**WELWYN HATFIELD BOROUGH COUNCIL
ASSISTANT DIRECTOR (PLANNING)**

DELEGATED APPLICATION

Application No: 6/2023/0374/FULL
Location: 11 Tolmers Gardens, Cuffley, Potters Bar, EN6 4JE
Proposal: Conversion and extension to existing dwelling to create four self-contained units with associated infrastructure
Officer: Ms Kirsty Shirley
Recommendation: Refused

| DWG NO   | P.01        | REVISION        | -        |

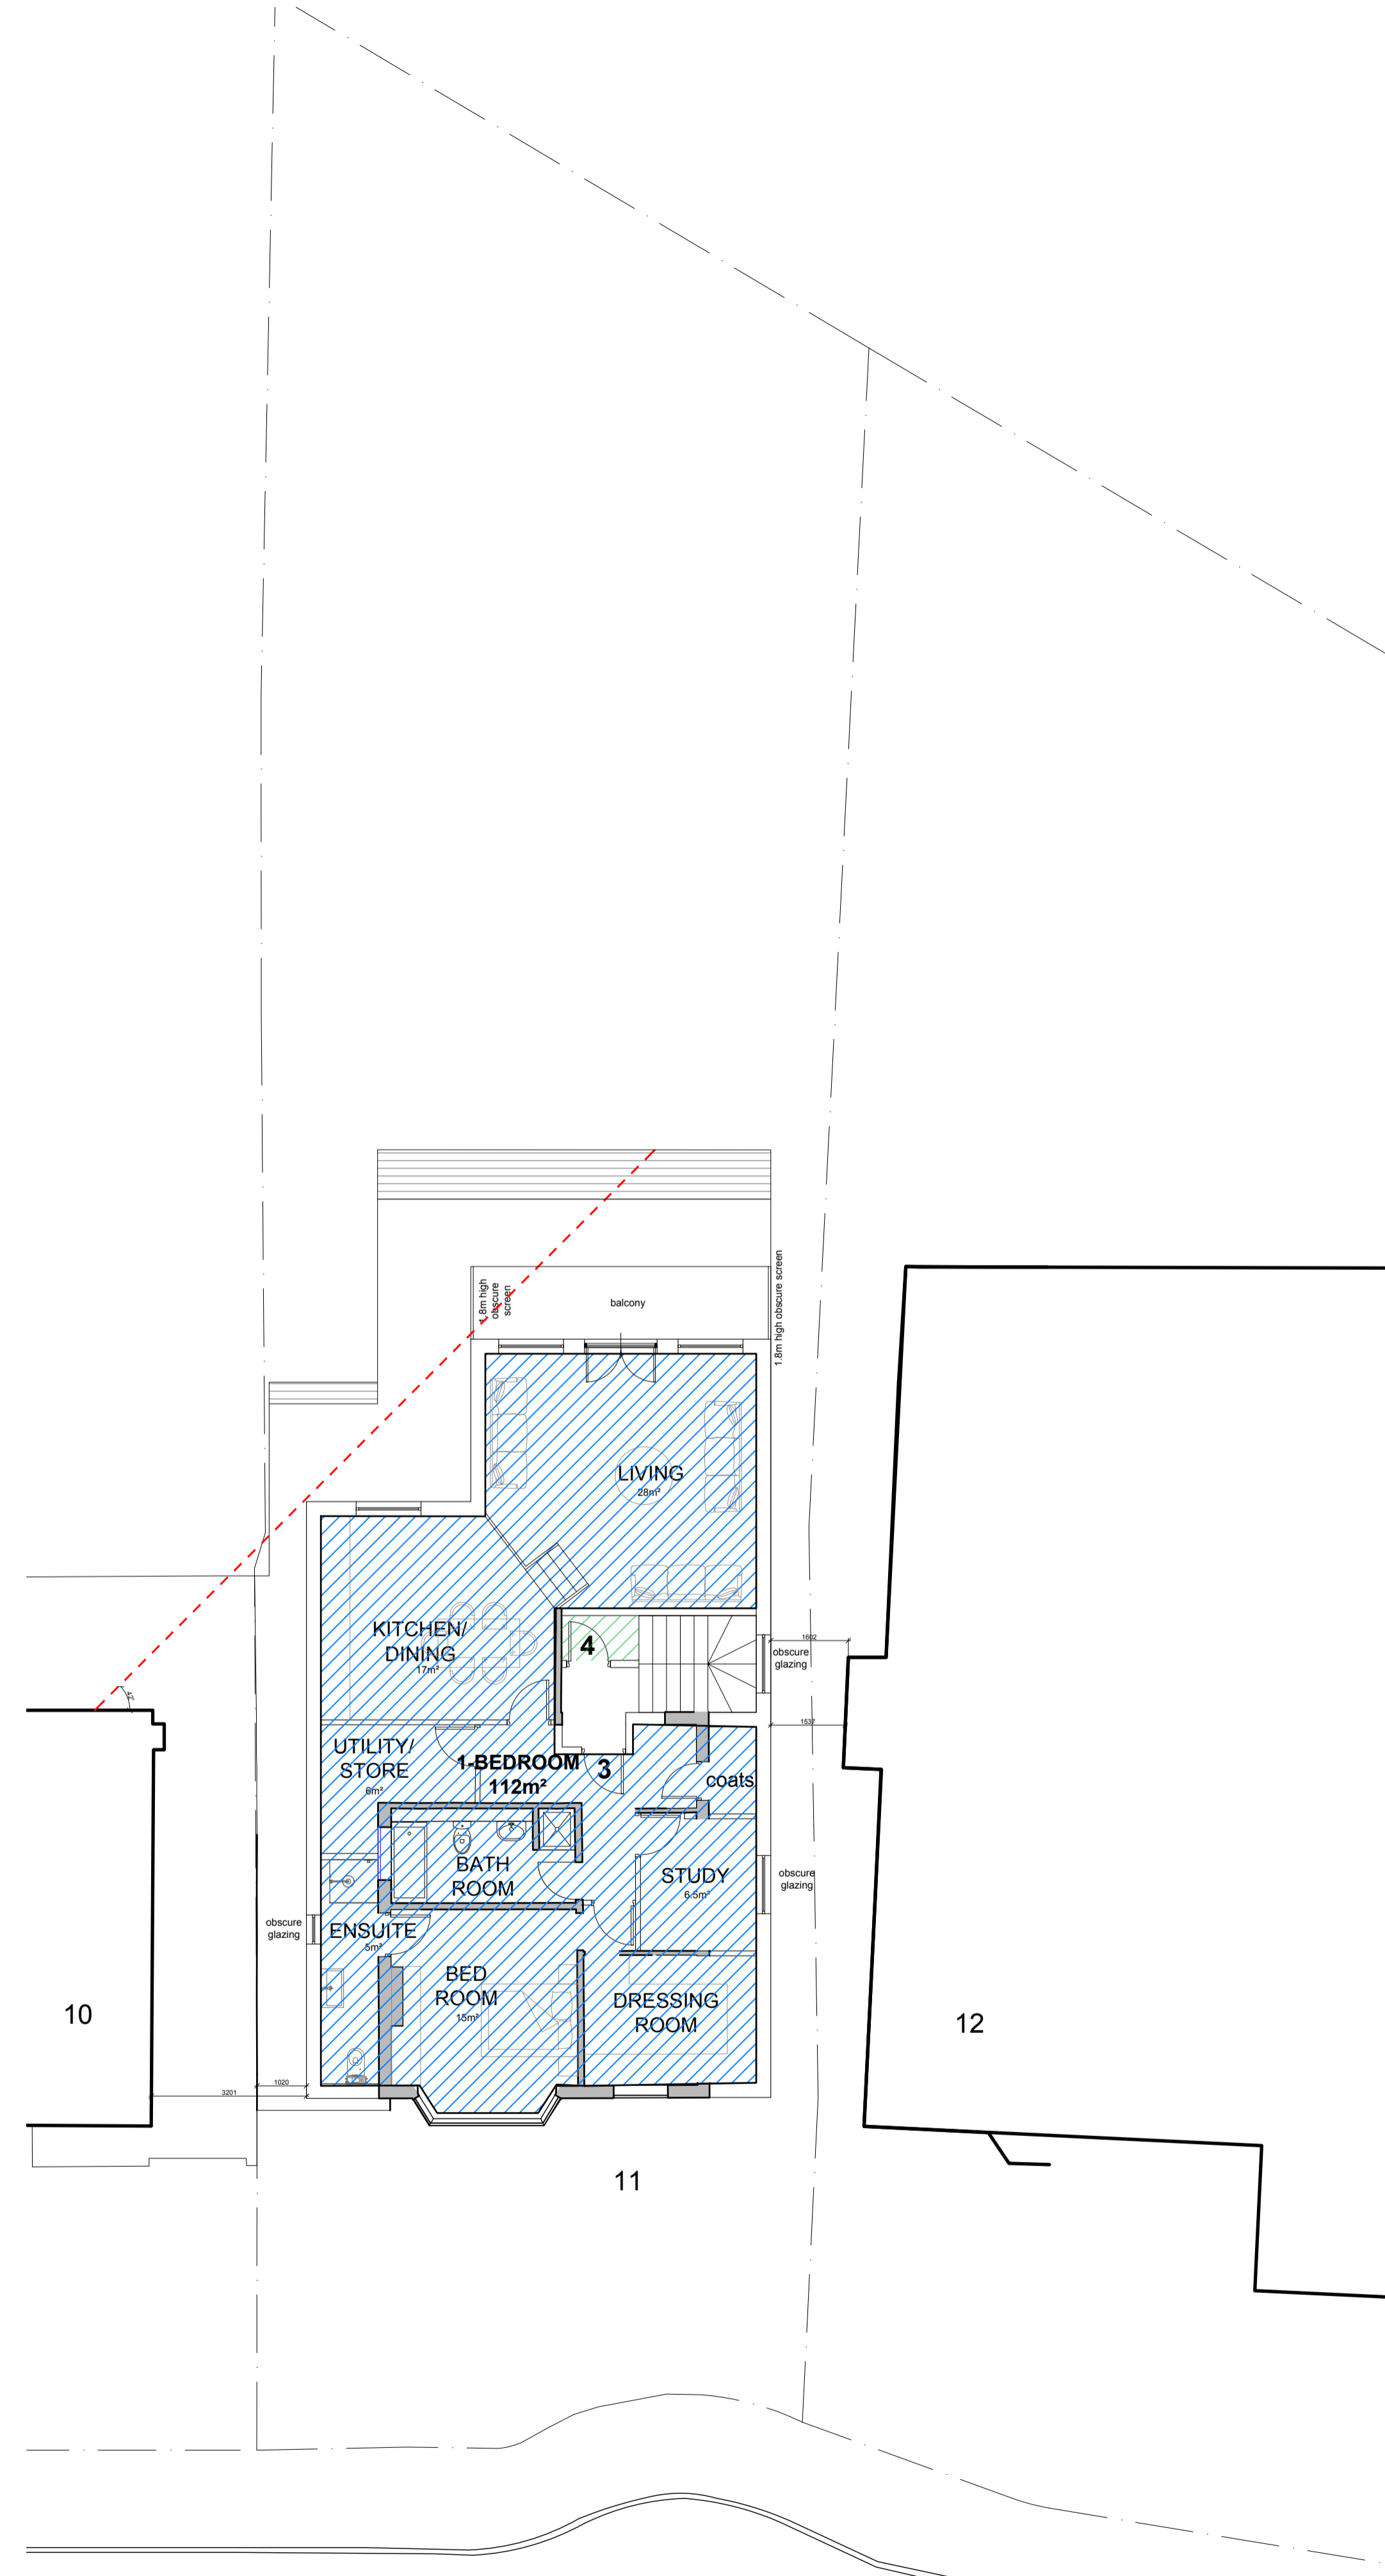
The proposed development would increase the size and scale of the existing dwelling on all floors, and notably at ground floor level due to a proposed single storey side to rear extension. The existing garage would be converted into a habitable space and the ground floor side extension would extend partly alongside the boundary with No. 9 before stepping in away from the boundary, with the ground floor extension set back from the shared boundary with No.12. The ground floor rear extension would occupy most of the current rear garden serving the dwelling within the site, with the remaining garden space to be private amenity space for the occupiers of flat 2. At first-floor level, there would be a partial rear extension which would extend across approximately two thirds of the first-floor rear elevation, served by a clipped gable roof, a dormer facing No. 12 and increase in ridge height to facilitate a habitable second floor space. There would be a separation distance above ground floor level between the proposed development and adjoining neighbours.

The entranceway to buildings within this area are located within the principal, front facing elevation. The consistent location of entranceways within the front facing elevation indicates access to a dwelling and is a key characteristic of the area. The access to the proposed building would be located to the flank elevation of the building facing No. 12. While it is noted that No. 12 is a flatted development, a key element in its design is its legibility within the street scene and to be perceived as a pair of semi-detached dwellings, which includes two front facing entranceways. The front elevation of the proposed building facing the street, through the absence of an entranceway, would be at odds with all dwellings/buildings in the area. This elevation would not respect or relate to the design and character of dwellings/buildings in the area. For this reason, it

<p>is considered that the proposed building would represent a poor standard of design as it would detract from the area's character. Accordingly, the proposal is considered to be in conflict with District Plan Policies D1 and D2; Policy SP9 of the emerging Local Plan; the SDG; and the NPPF.</p>
<p>Living condition for future occupiers</p>	<p>District Plan Policy D1, in conjunction with the SDG, outlines that development will be required to provide a good standard of amenity for buildings and external open spaces. Paragraph 130 of the NPPF outlines that decisions should always seek to secure high quality design and a good standard of amenity for all existing and future occupants of land and buildings. Emerging Policy SADM11 requires, as a minimum for proposed dwellings, to meet the Nationally Described Space Standard, unless it can be robustly demonstrated that this would not be feasible or viable. The Standards outline the minimum requirements floor space and storage for new dwellings.</p> <p>The proposed flats would be of adequate size to meet local and national policy. While the flats are described as one-bedroom, the proposed flats would have sizeable studies that could be feasibly used as bedroom, particularly if combined with the utility rooms shown for flats 1, 2 and 4, or coat room shown for flat 3. The studies shown for flats 2 and 4 would be approximately 6m² and the studies for flats 1 and 3 would be approximately 6.5m², with each study at least 2.15m wide. The floor area of the studies would only be marginally under the NDSS standards of 7.5m² and could provide sufficient space for the area to be utilised as a bedroom, and would exceed the standards of the NDSS should the studies be combined with their respective adjoining utility/coat/storage rooms. It is therefore likely throughout the lifetime of the building that the flats would be used as two-bedroom dwellings.</p> <p>In terms of private amenity space, Policy D1 of the District Plan, Policy SADM11 of the Emerging Local Plan and the SDG requires all residential development to incorporate private amenity space for the use of residents. The Council does not apply rigid standard sizes but space should be functional and usable in terms of its orientation, width, depth and shape. The Council will look at the size of the unit proposed in relation to the size of the garden.</p> <p>The plans submitted with this application indicate that the rear garden space serving the flats at adjoining neighbour No. 12 would also serve the residents of the proposed development. The communal amenity space would be shared across a total of 12 flats. Sharing the amenity space across 12 flats was also proposed in refused application 6/2022/0922/FULL. The reduction in ground floor projection in this application when proposed to application 6/2022/0922/FULL allows for further amenity space for use of the residents, with private amenity space provided for the occupants of flat 2 and a balcony for the occupants of flat 3.</p> <p>Each flat at the proposed development and existing development at No. 12, would be inhabited by at least one person, with potentially more occupants given bedrooms would likely be shared and flats have potential for renovation to provide a second single bedroom. Private amenity space would be provided for the occupants of flat 2 and flat 3, via a modest garden and balcony respectively. While the proposed communal amenity space has increased from previous application 6/2022/0922/FULL, it is considered the amenity space would still be insufficient in size for the number of residents it would serve. Access to the communal amenity space for future occupiers of the development would also be inhibited by the location of the bin store area.</p>

<p>Furthermore, the proposed cycle storage location would interrupt the form and use of the amenity space, reducing useable amenity space surrounding the cycle storage areas from being useable outdoor space. The proposed amenity area would diminish the ability of residents of the cumulative 12 flats from undertaking outdoor recreation, including play, as well as reducing opportunities of matters including undertaking domestic tasks such as the drying of washing. The proposed communal amenity space would therefore prevent future and existing occupiers to experience appropriate living conditions.</p> <p>The development has therefore failed to overcome refusal reason 2 of application 6/2022/0922/FULL and would be in conflict with District Plan Policy D1, Policy SADM11 of the emerging Local Plan, the SDG, and NPPF.</p>
<p>Impact on neighbours</p>	<p>Eleven neighbouring objections have been received for this development. Concerns have been raised regarding the legality of the development, effect on house prices, inaccurate information submitted, diminished views, overdevelopment, overlooking and loss of privacy, loss of sunlight, insufficient car parking, loss of amenity space, bin and cycle storage location, noise and dirt issues as a result of construction, and sewerage issues.</p> <p>House prices and diminished views are matters in the private interest, whereas planning operates in the public interest. These matters are therefore not a material planning consideration in this case.</p> <p>Concerns regarding the legality and sewerage of the proposal are matters that are managed outside of the planning system.</p> <p>Concerns regarding inaccurate information and issues as a result of construction have been addressed later in this report.</p> <p>In terms of privacy, a first-floor window would be inserted into the flank elevation facing No. 9. This window would serve a non-habitable space and so could be secured by condition to be obscured glazed and non-opening in the event of an approval to protect the privacy of the occupiers of No. 9. A 1.8m obscured screen for each side elevation of the first-floor rear balcony serving flat 3, is proposed, which would protect the privacy of the occupiers of No. 9 and No. 12.</p> <p>Windows would be inserted across the ground floor, first floor and roof level of the flank elevation that faces towards No. 12. The first-floor and roof level windows would be obscured glazed, with a first-floor and roof level window serving non-habitable spaces. However, a first-floor window proposed to be obscured glazed would serve a study, with no other windows serving this space. A study would be a habitable space, could double as a home office and, as discussed earlier, has the scope to be used as an additional bedroom in future. It is considered that an obscured glazed window would not allow for adequate light within the habitable space. It would be a gloomy space and result in a poor standard of accommodation for future occupiers of this flat</p> <p>Rooflights are proposed within the front, rear and side facing roofslopes. The positioning and orientation of the rooflights would not overlook adjoining neighbours and would maintain the privacy of adjoining occupiers.</p> <p>While it is acknowledged that the development would add considerable bulk</p>

2. The proposal would result in inadequate and insufficient amenity space provision for both existing occupiers of No. 12 Tolmers Gardens and future occupiers of the proposed development, as well as resulting in poor standard of living conditions for the future occupiers of flat 3 by virtue of inadequate natural light . The development is therefore contrary to contrary to Policy D1 of the Welwyn Hatfield District Plan 2005, Policy SADM11 of the Welwyn Hatfield Borough Council Draft Local Plan Proposed Submission 2016, the Council’s Supplementary Design Guidance, and the National Planning Policy Framework.

<b>11 TOLMERS GARDENS</b>			
Potters Bar, Cuffley, EN6 4JE			
CLIENT	Sonar Group Ltd		
PROPOSED ELEVATIONS & SECTIONS			
SCALE	1: 100 (A1)	DATE	Jan 2023
DWG NO	P.03	REVISION	-

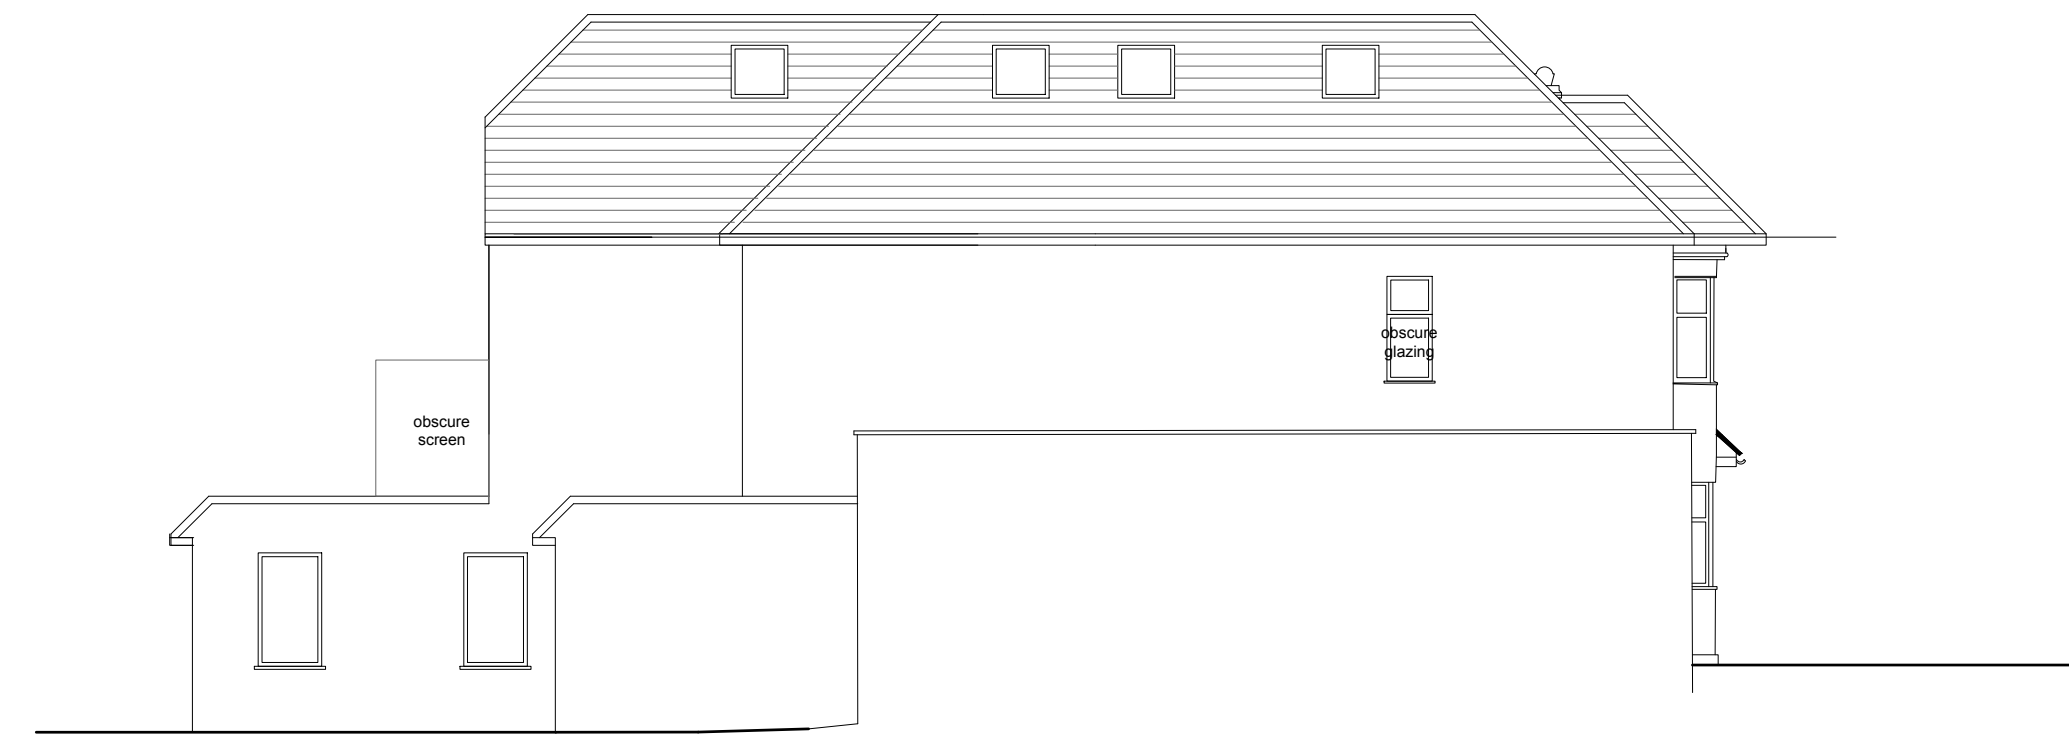
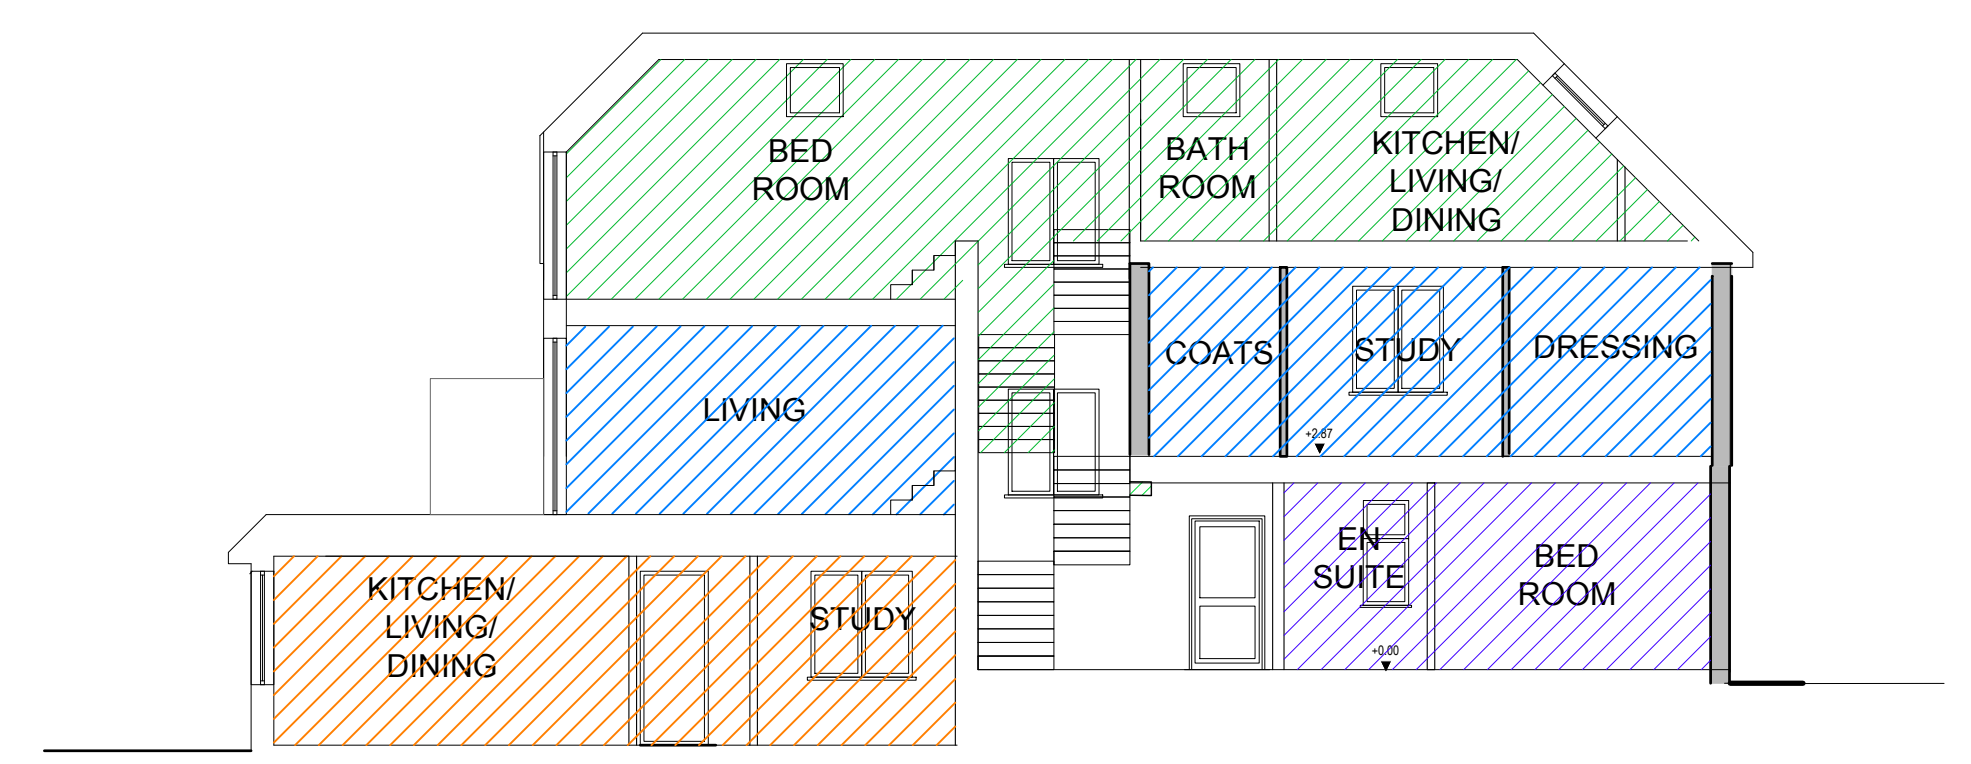
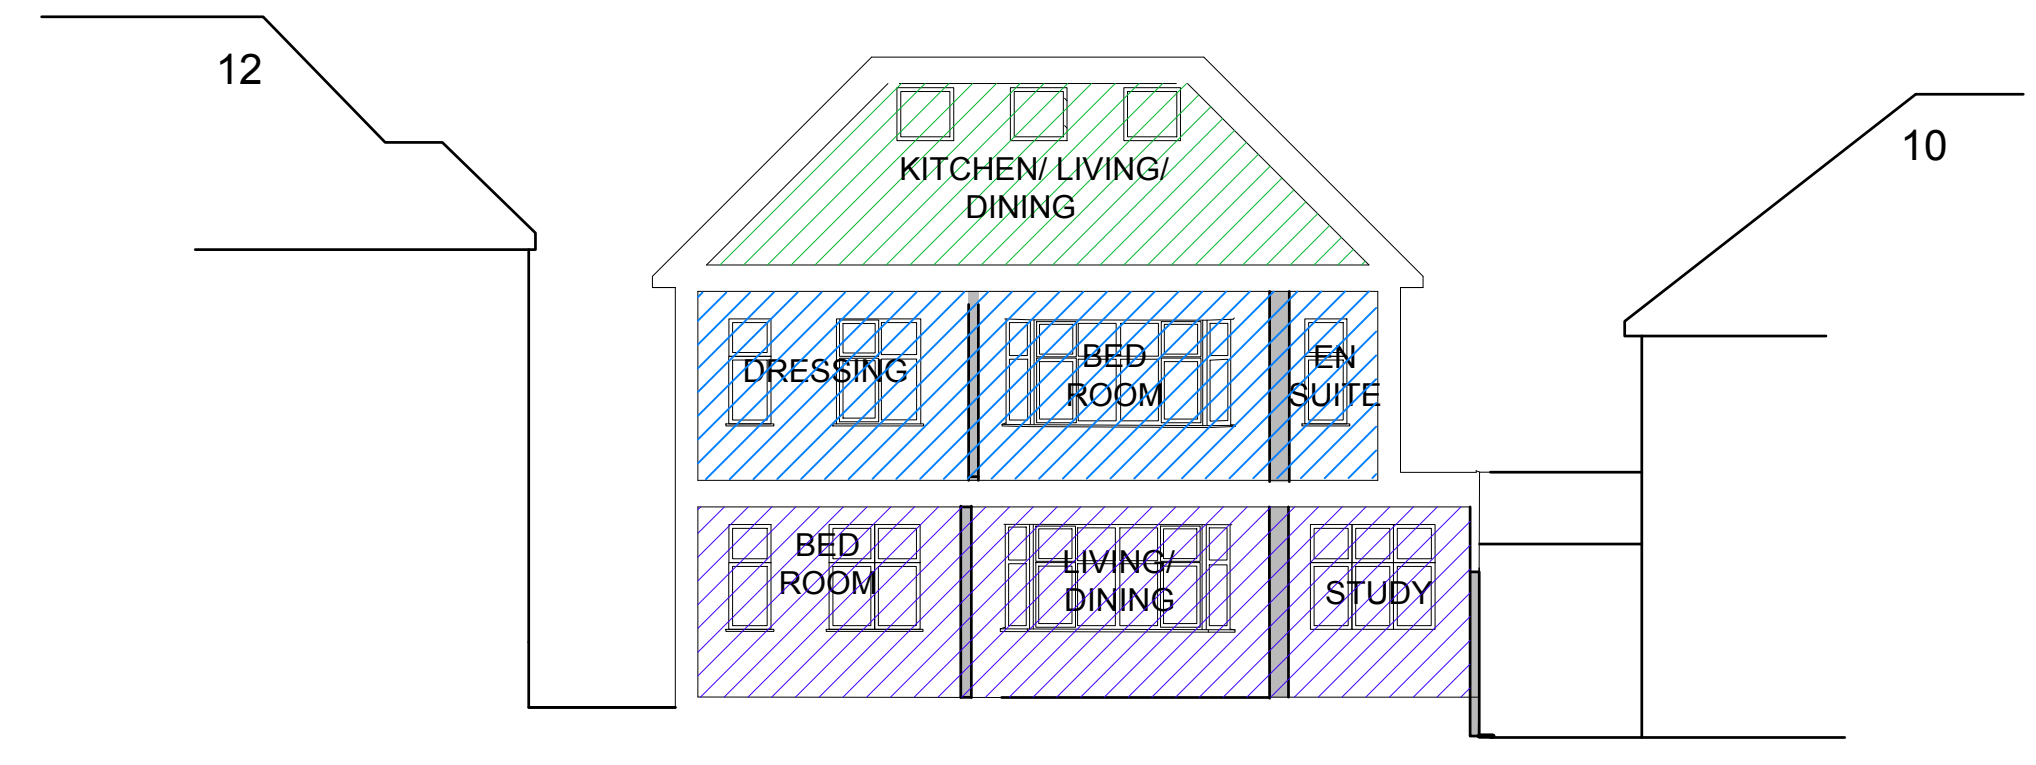
The proposed extensions and enlargements would result in a substantially larger building on the site. It is however noted that the application site has a greater area than the existing curtilage of No.11. The eaves and ridge height of the resultant development would adequately respect the stepped building heights of neighbouring properties on its row, there would be sufficient set-in distance at first floor level and above, and the existing building line would be maintained.

The building would have a crown roof and it is noted that the building at No.12 has the same type of roof form. As such, there is no in principle objection to this type of roof (subject to precise design details which can be secured by condition).

The clipped gable roof to the rear would not contrast unacceptability to the roof forms in the immediate locality which are varied and the side dormer would be subservient in scale to the roof slope.
